Your Ref:
Our Ref: EP/147/08/
Please ask for:
Mr J Smith

15th December 2008

Single storey front extension
28 Meadow Park East Preston

DRAWING: 0820/01

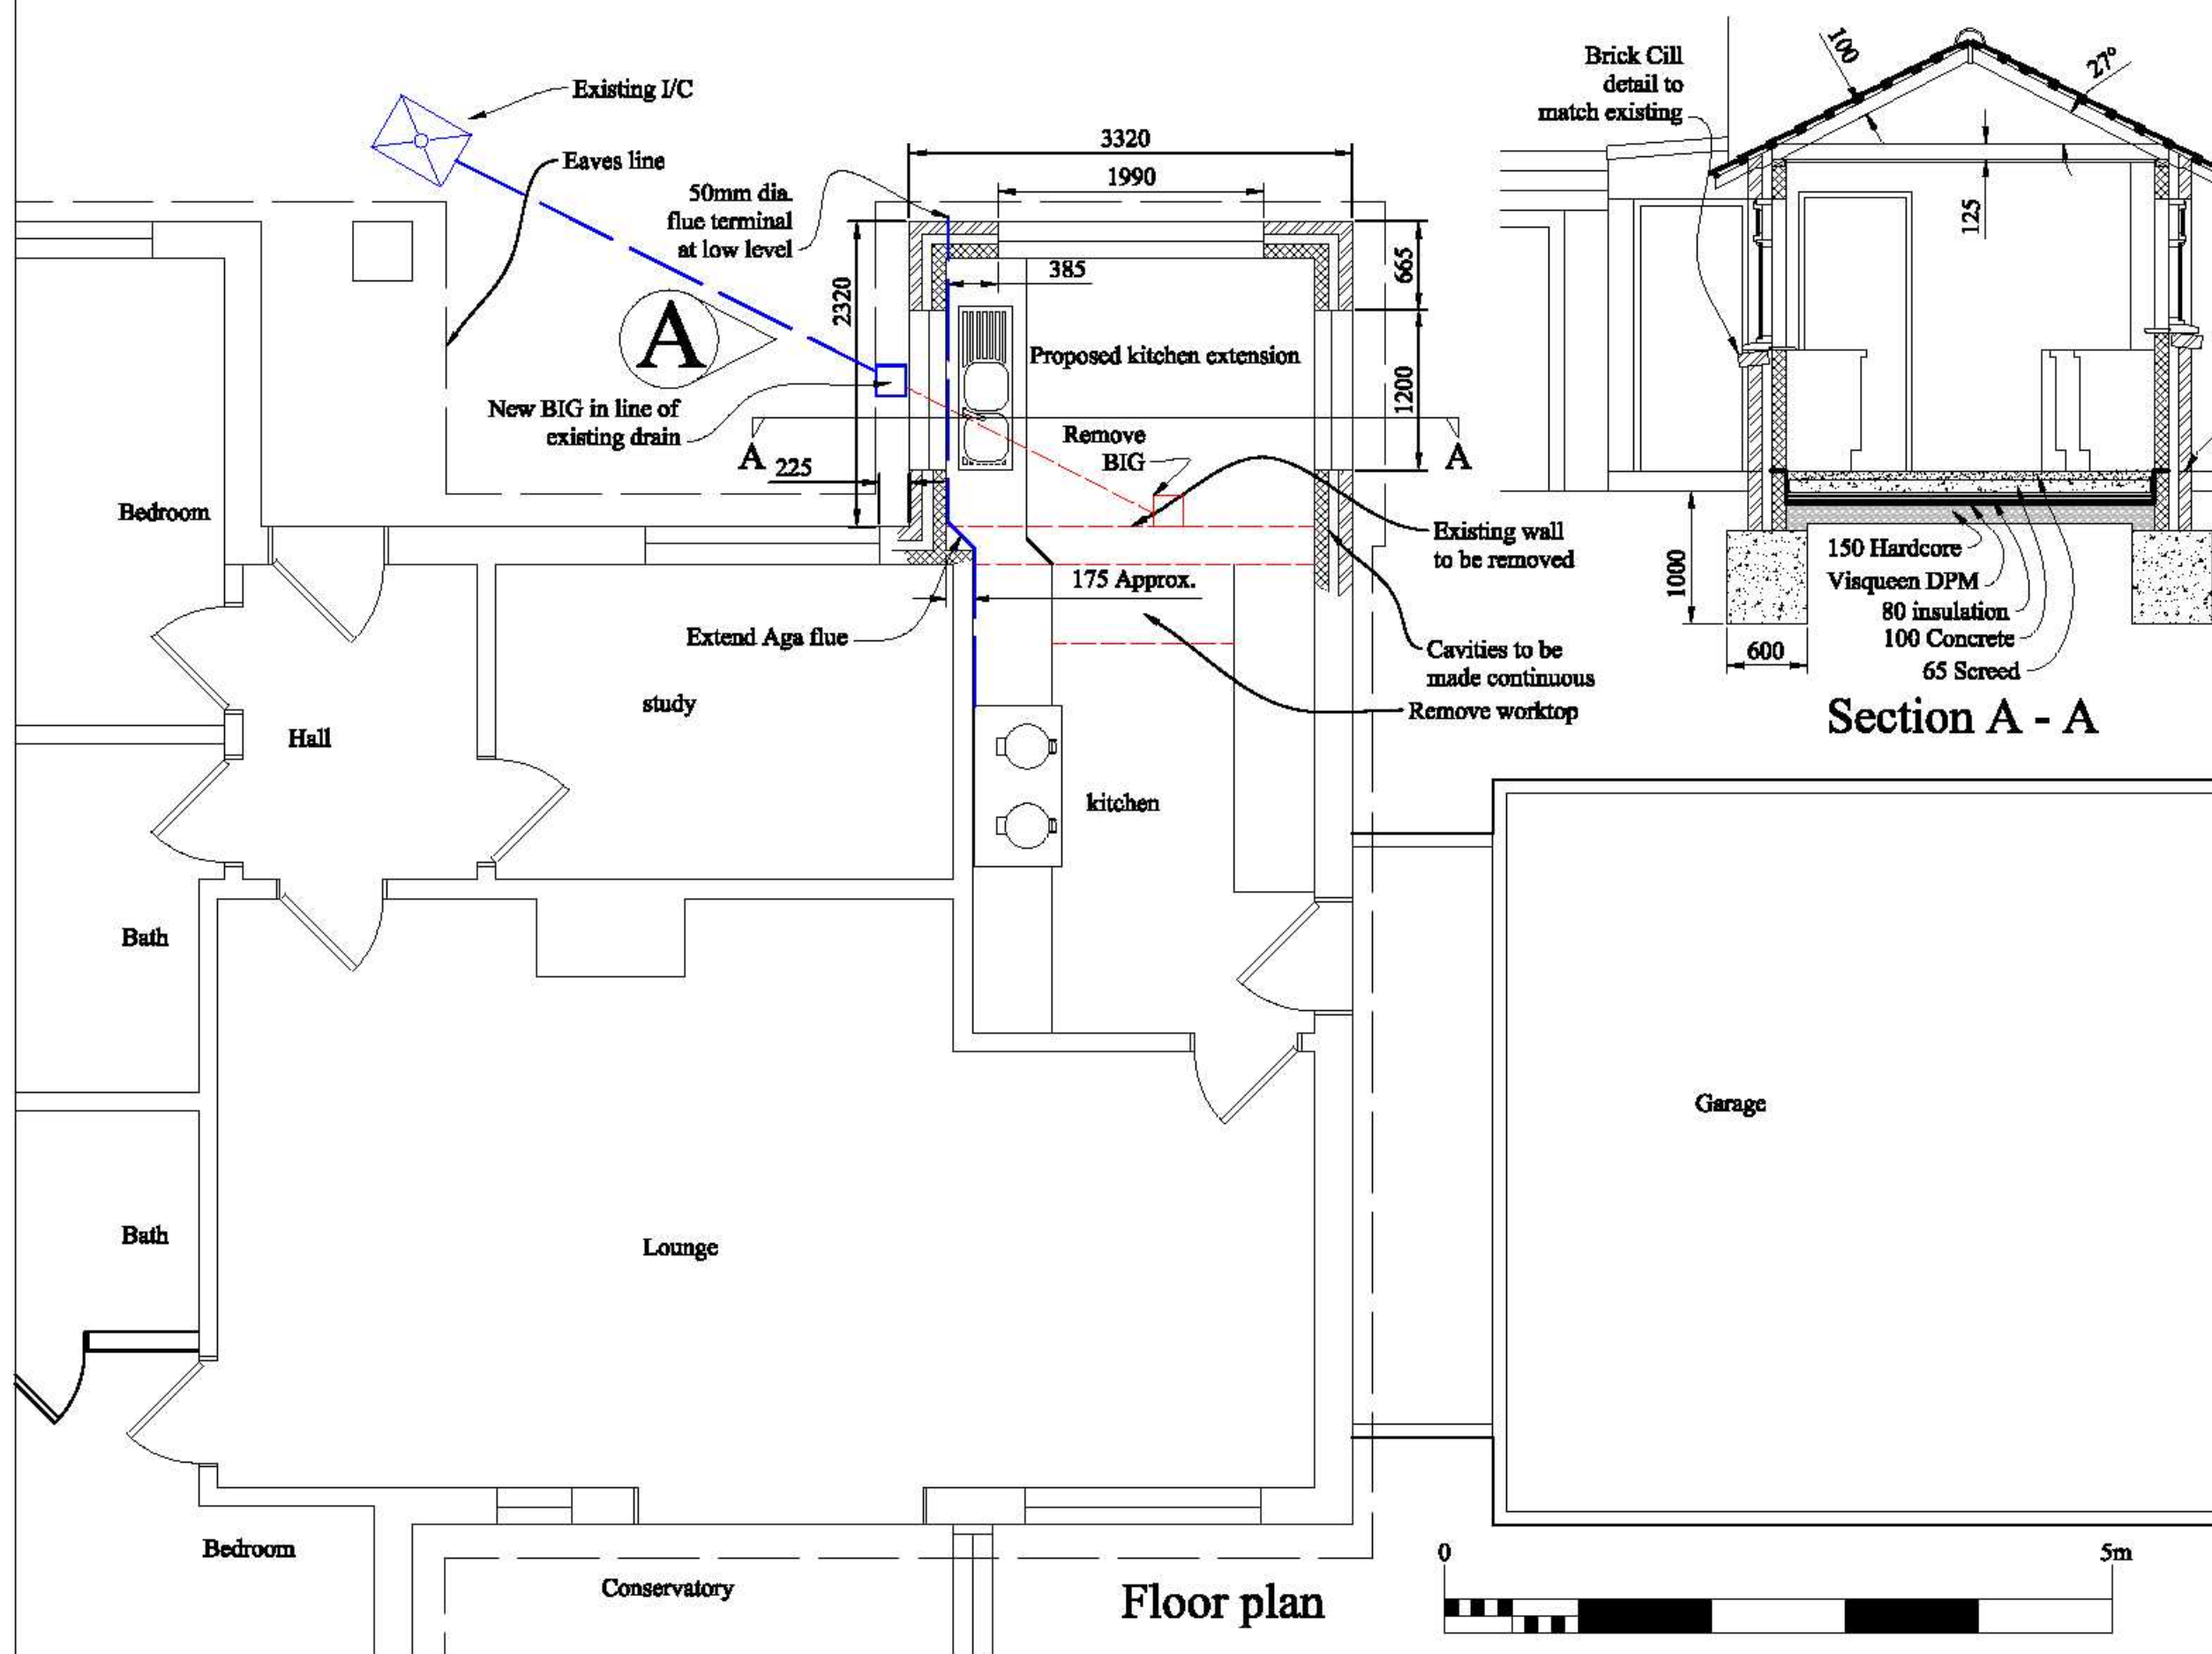
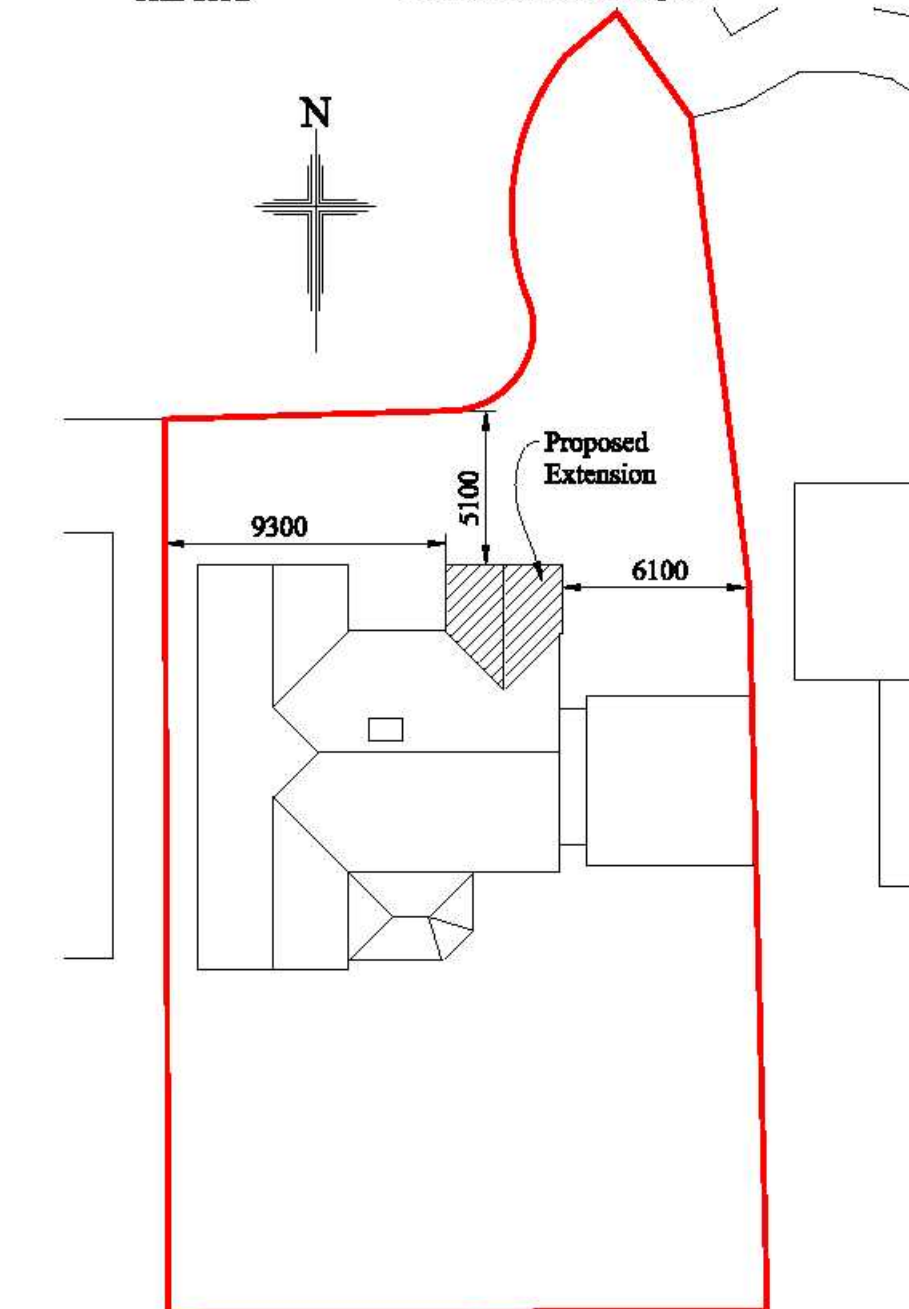
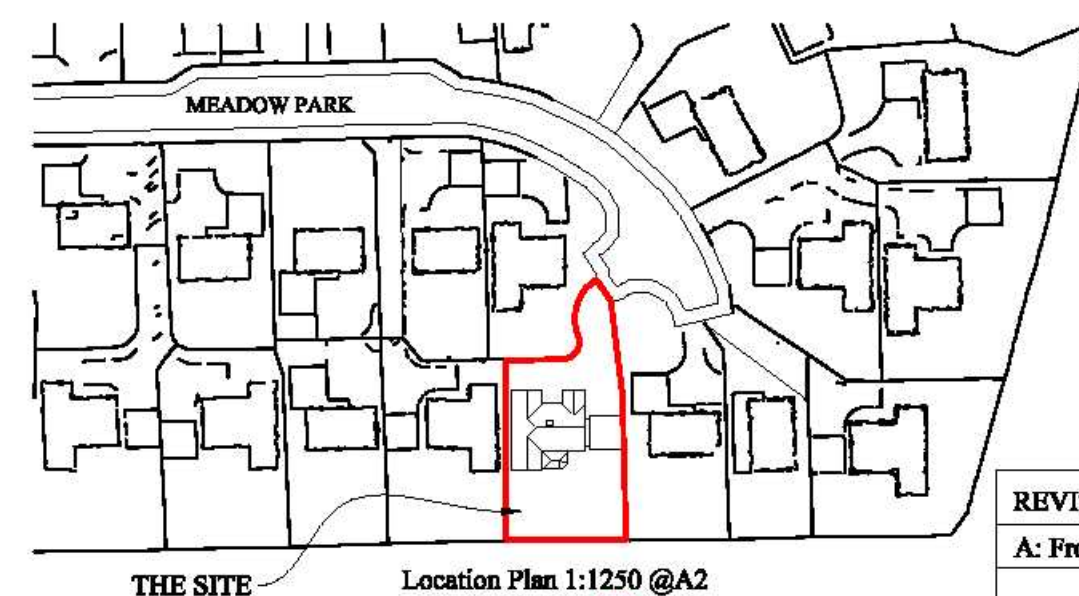
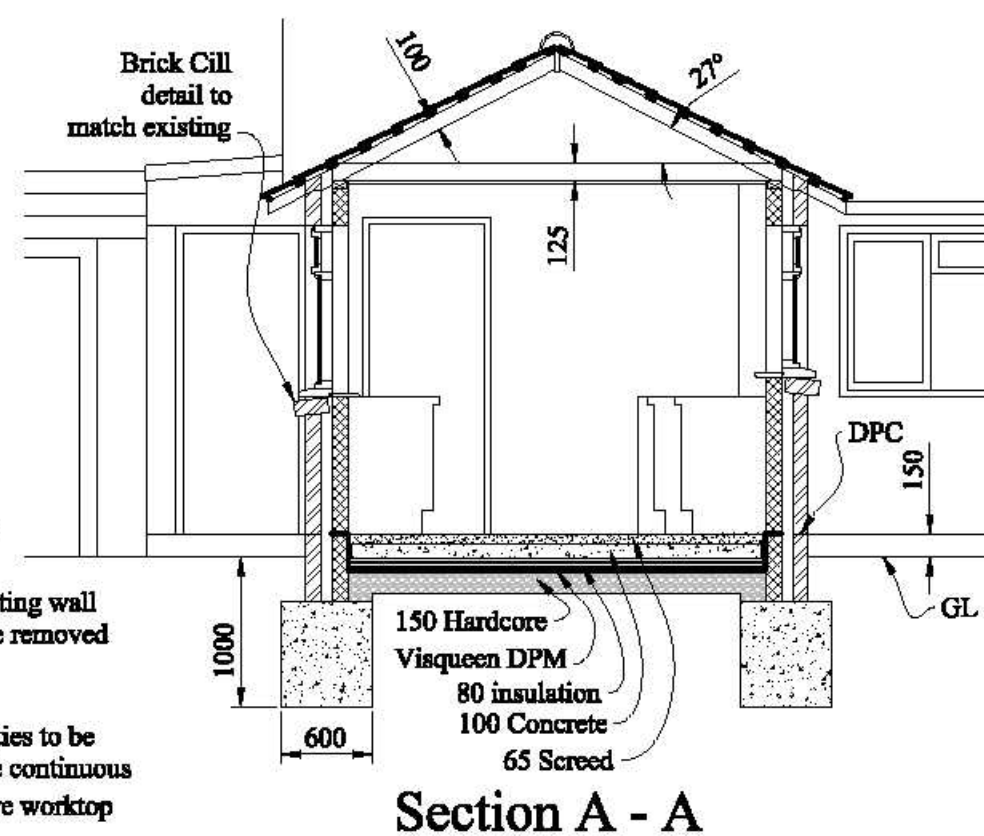
The Committee NOTED the numbering on the two plans did not match. The site plan referred to the plot as No.17 whereas the actual plan was No. 28. ☐

The Planning Committee had no objections to raise against this Application but would bring to the attention of ADC that the numbering was not consistent. ☐
